Subject: FW: CM/48/201/DOC - Bairds Farm Shop, Field Rear of Crookthorn Lane, Climping, BN17 5SN

Principal Planning Officer,
Directorate of Place

Engineer, Adur & Worthing Councils

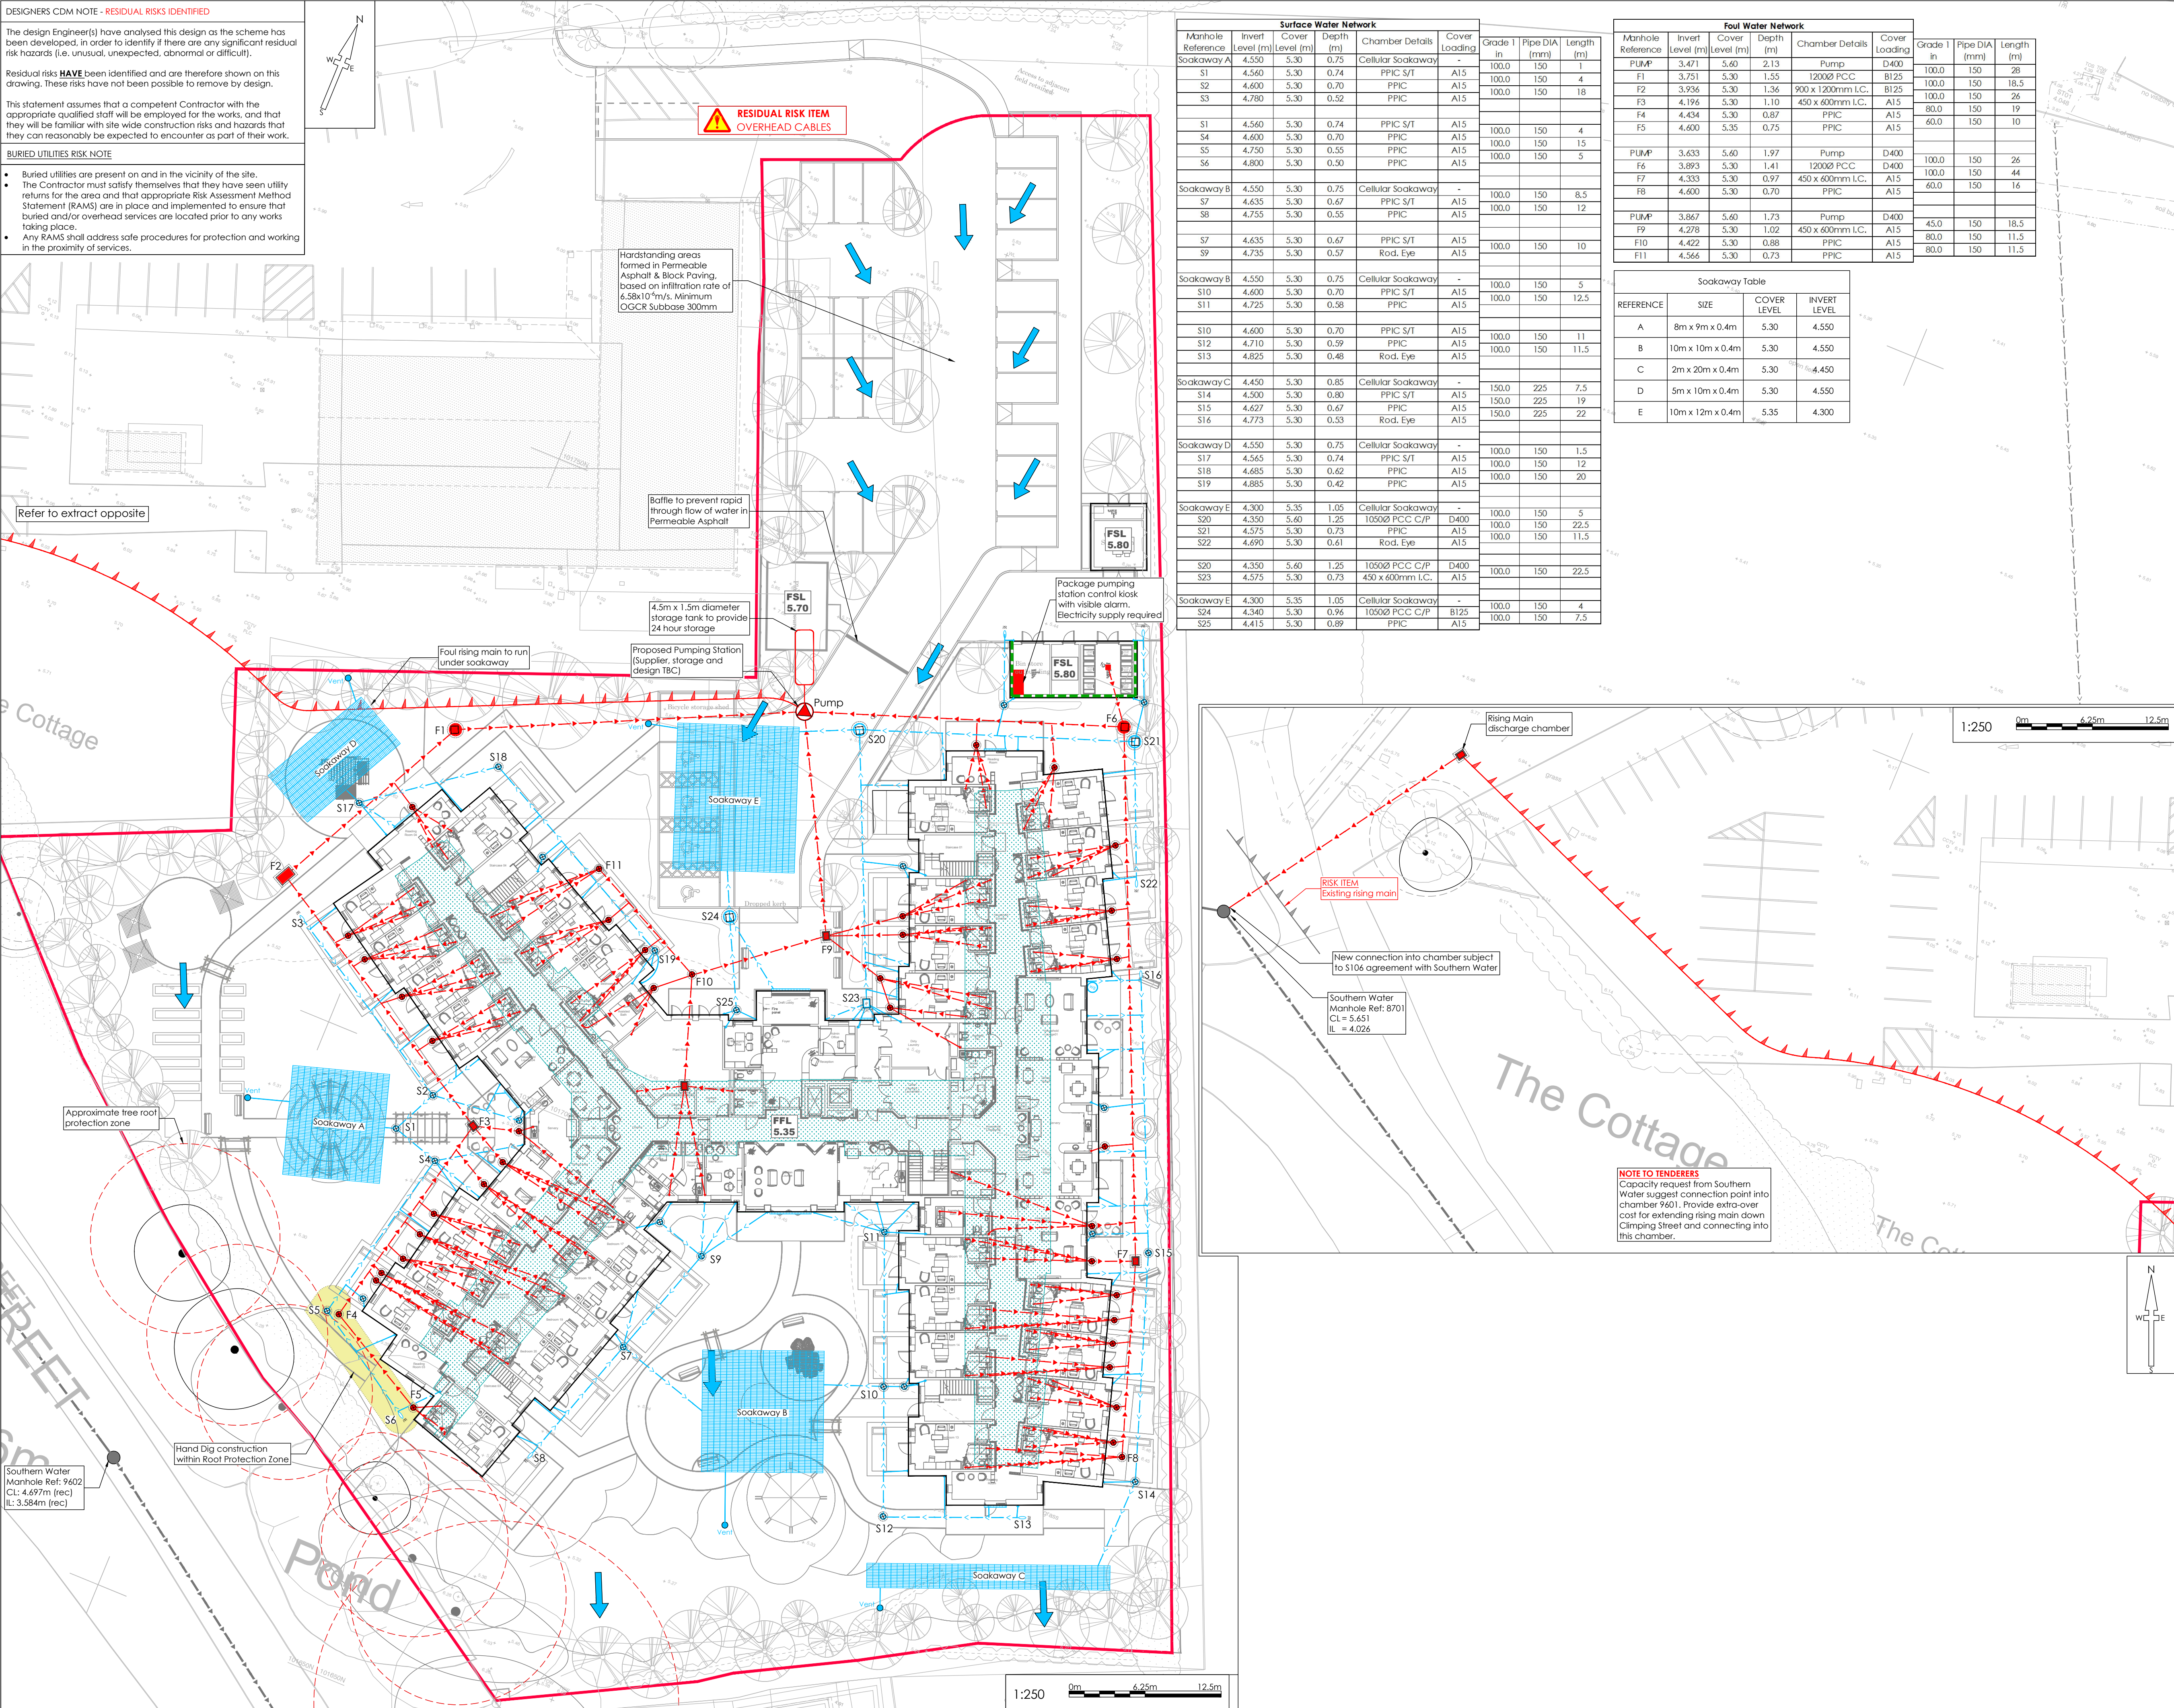
1. Please supply a figure showing the groundwater monitoring locations.
2. I note that Soakaway E has an invert at over 1m depth, based on the groundwater monitoring results near this location the design may need to be revised. (potentially link provided between permeable paving and this soakaway to ensure you have the required volume above peak groundwater level?)
3. Please supply a catchment plan- i.e. a layout which clearly shows the areas (and the size of these areas) that are draining to each soakaway.
4. Please label all pipes with diameters and falls.
5. We will require updated construction detail drawings and maintenance manual. Please include on the construction detail drawings the required crate type- or criteria they have to fulfil in terms of minimum acceptable cover depth.

1. We have added on the groundwater test locations and referred the depths back to existing ground levels to provide the levels of the groundwater. *Okay, point closed.*

2. Soakaway E does have a low invert however this is purely a result of having to provide additional cover over the crates to ensure that they will be able to take vehicle loadings. Lifting the crates higher will compromise their strength however we intend to link the permeable sub base with the soakaway to provide additional hydraulic storage to address this. We attach the calculations for the soakaway and soakaway plus permeable paving. *The peak groundwater level in this area is above the top of crates. It doesn't appear that you have sufficient volume in the permeable paving sub-base alone. I have calculated you have 22.68m³ volume available in the permeable paving sub-base, calculations indicate you require 55.6m³ of volume. Adequate storage must be provided above peak seasonal groundwater level, please demonstrate you can provide this. Please confirm how you intend to link the crate and permeable paving, is it via increasing the sub-base depth, if so then you may be providing the storage required.*

3. Please find attached the catchment plan. *Okay, point closed.*
4. Pipe runs have been labelled with pipe size and gradients. *Okay, point closed.*
5. Updated details drawing and maintenance plan attached. *Okay, point closed.*

PERMEABLE ACCESS ROAD DETAIL

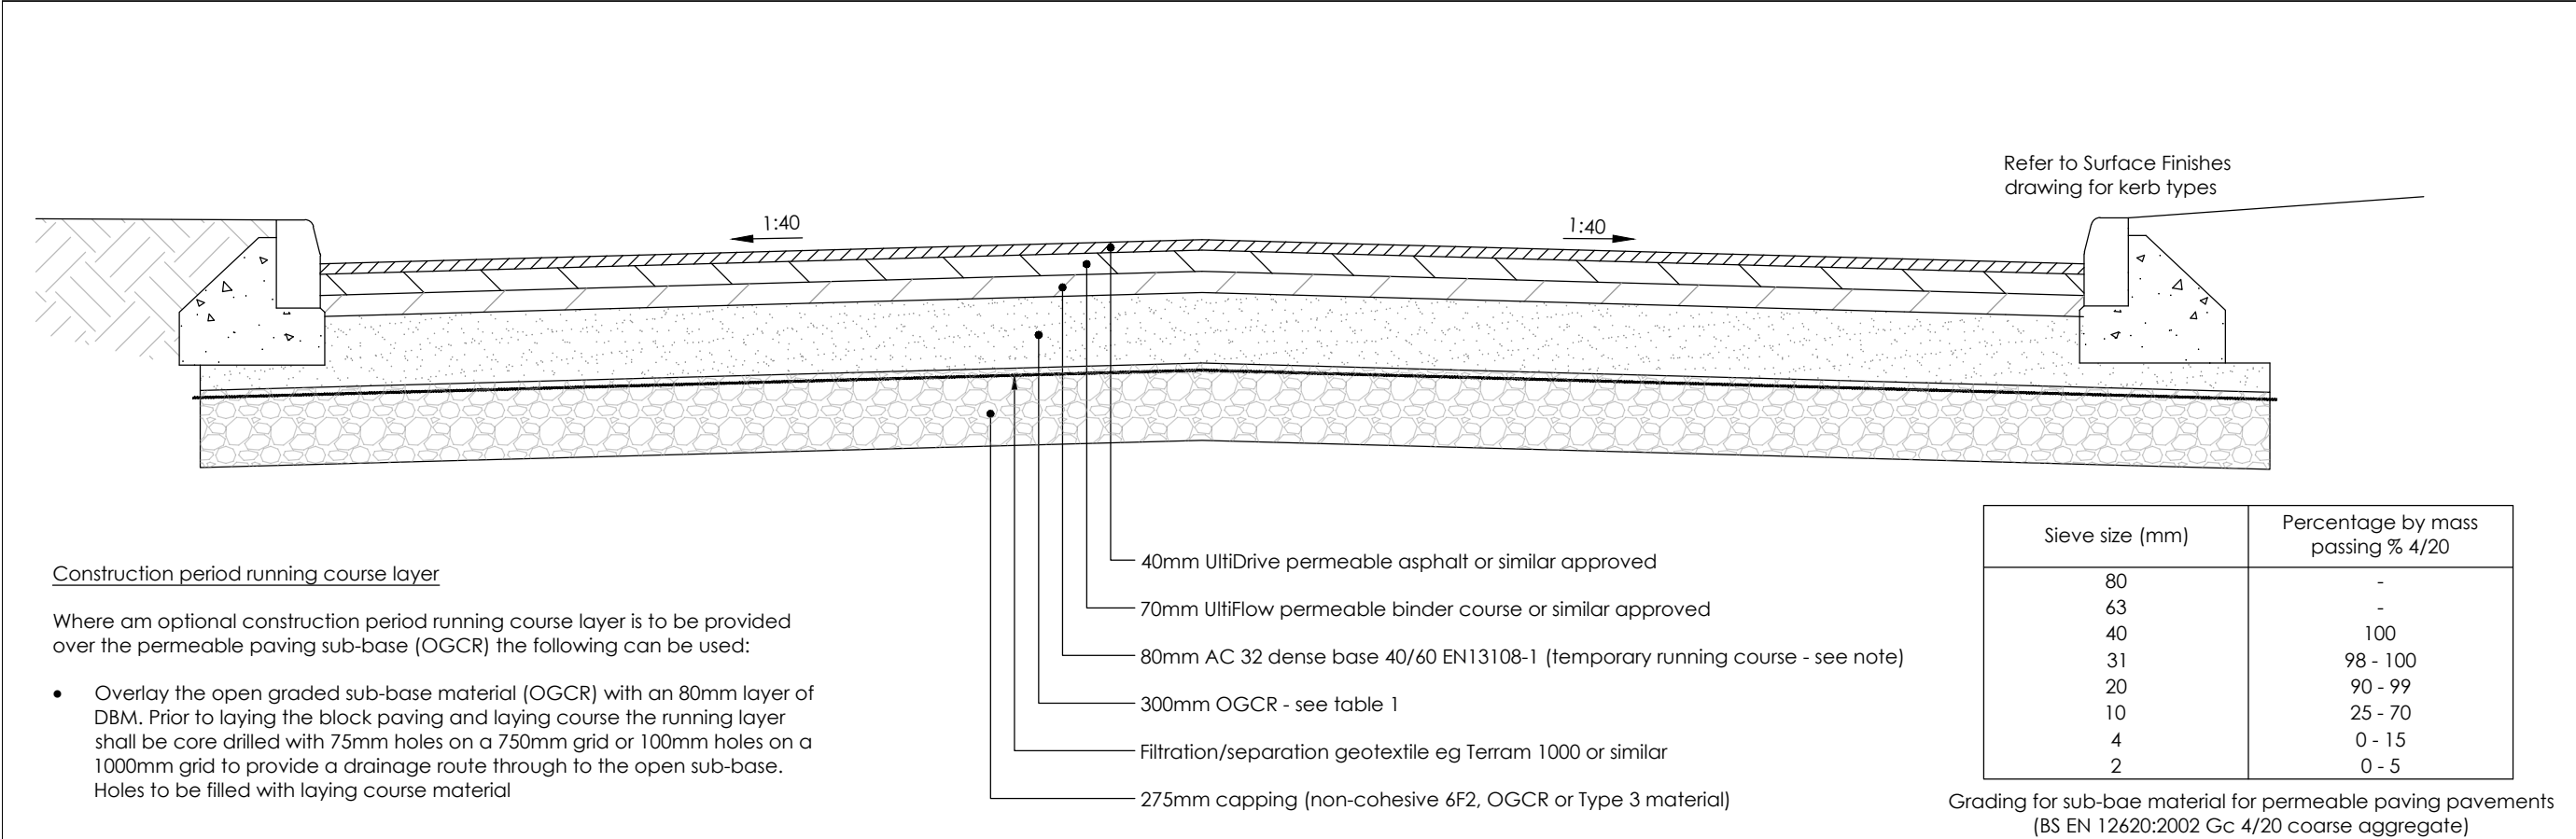
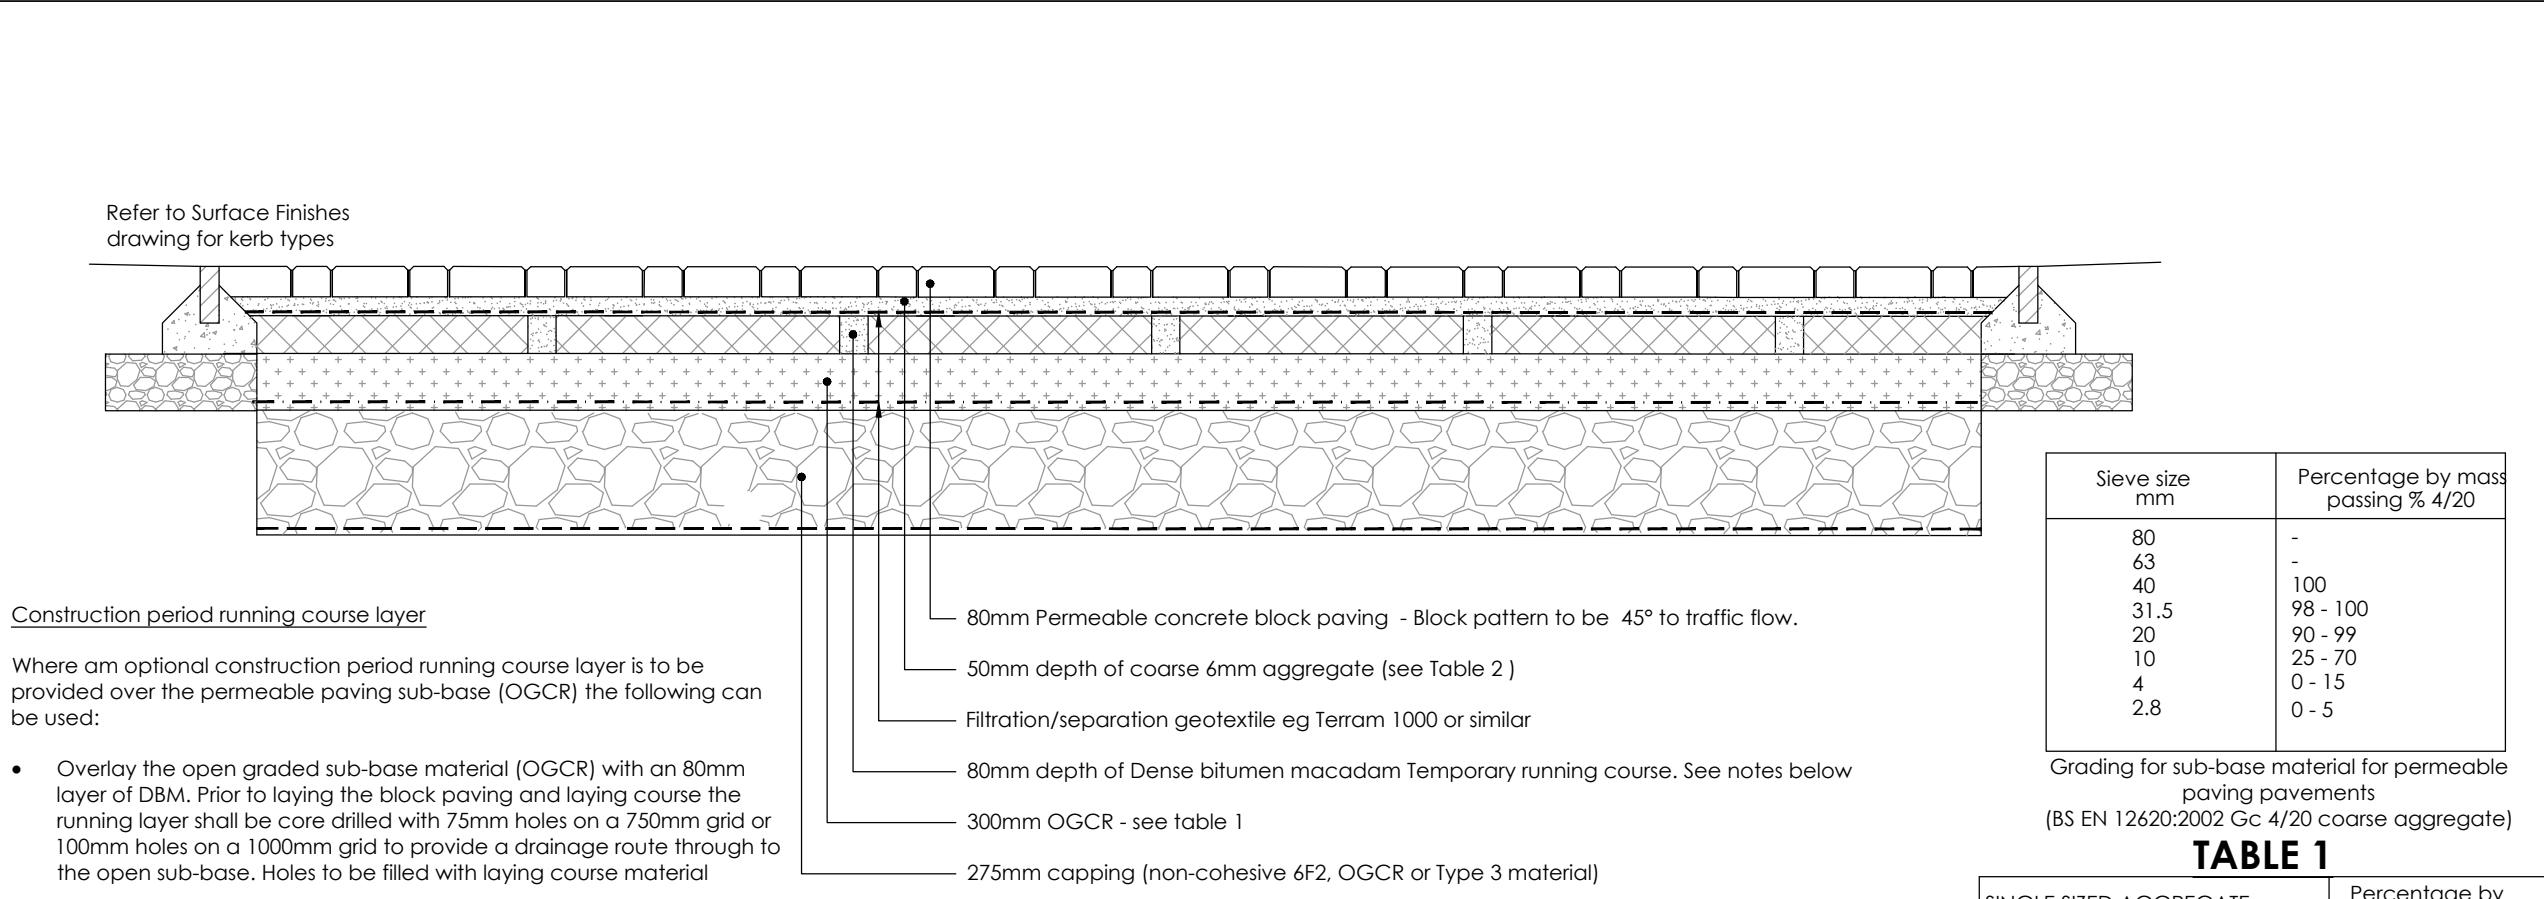
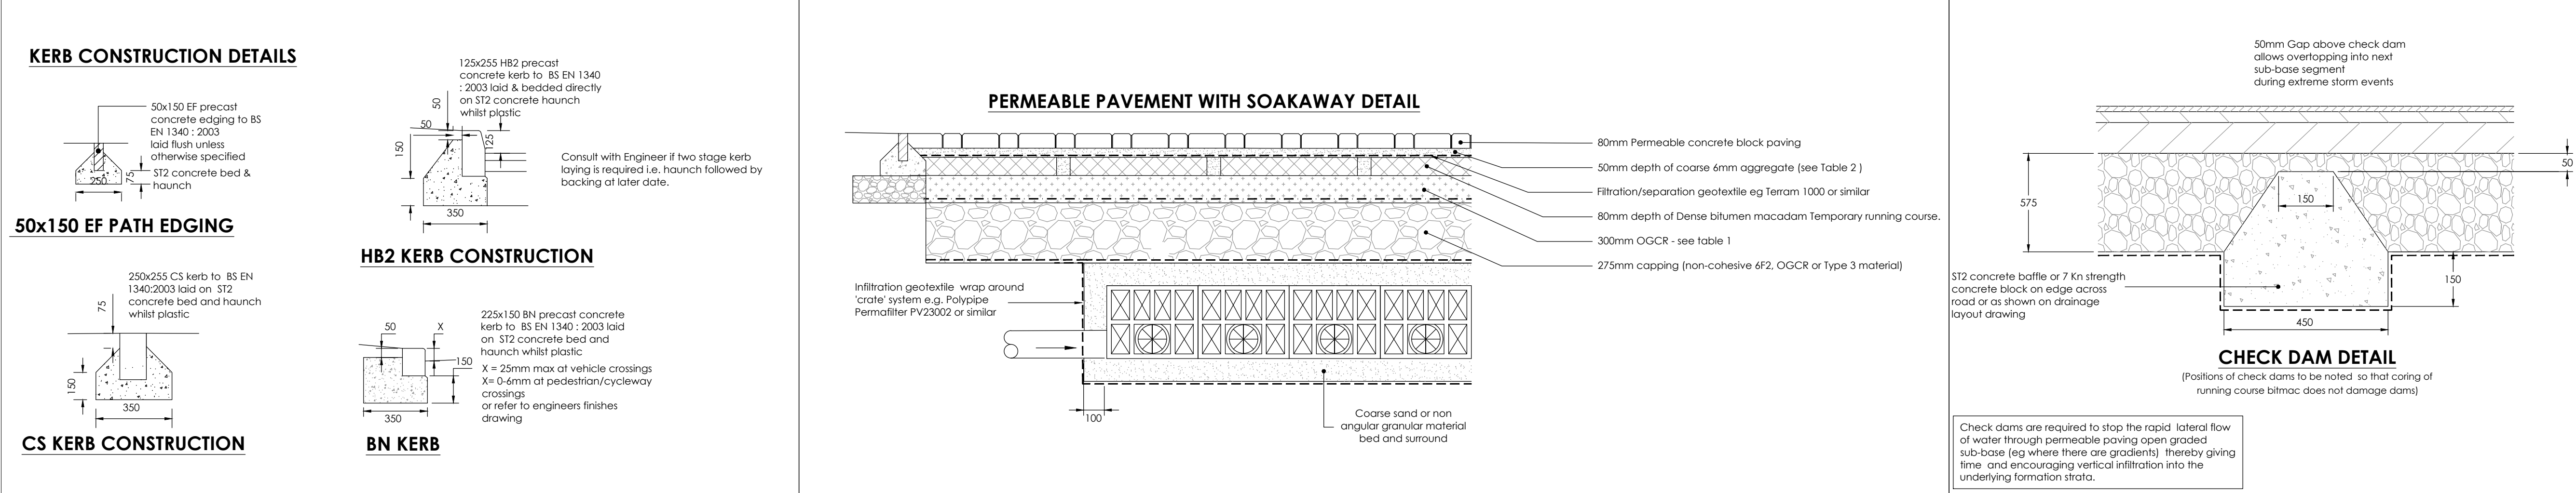
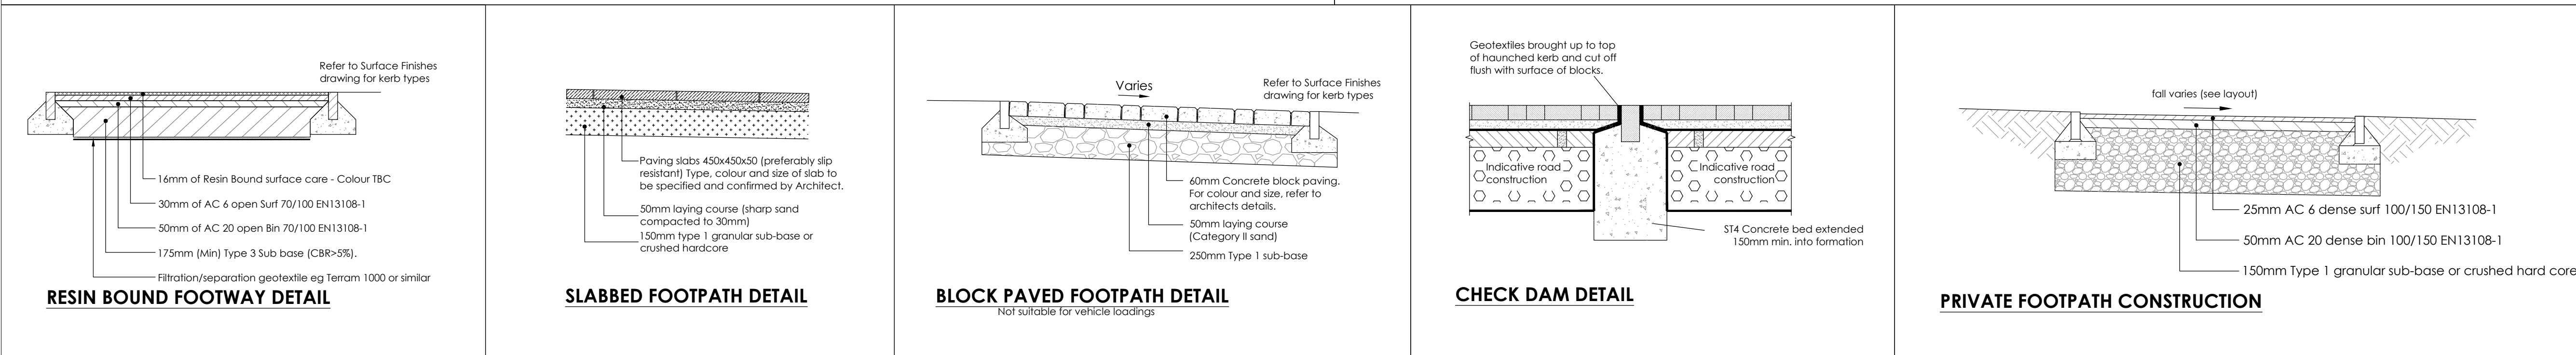
You haven't included a cap volume depth within your calculations. The 0.3 porosity does not extend to the height that is in the calculations, water is above the sub-base. Please apply an appropriate cap volume depth.

Please provide a construction detail drawing which clearly shows the linkage of the permeable paving sub-base with the crates here. I note you have also now introduced a baffle into the sub-base here, please provide a construction detail drawing of this.

That's fine and we have added a cap on the permeable paving as requested. To ensure there are no issues we have added a secondary soakaway within the soft landscaping to provide the 'buffer' should this be needed.

Also attached are the updated details drawing showing the baffle detail and the detail for where we have soakaways below the permeable paving.
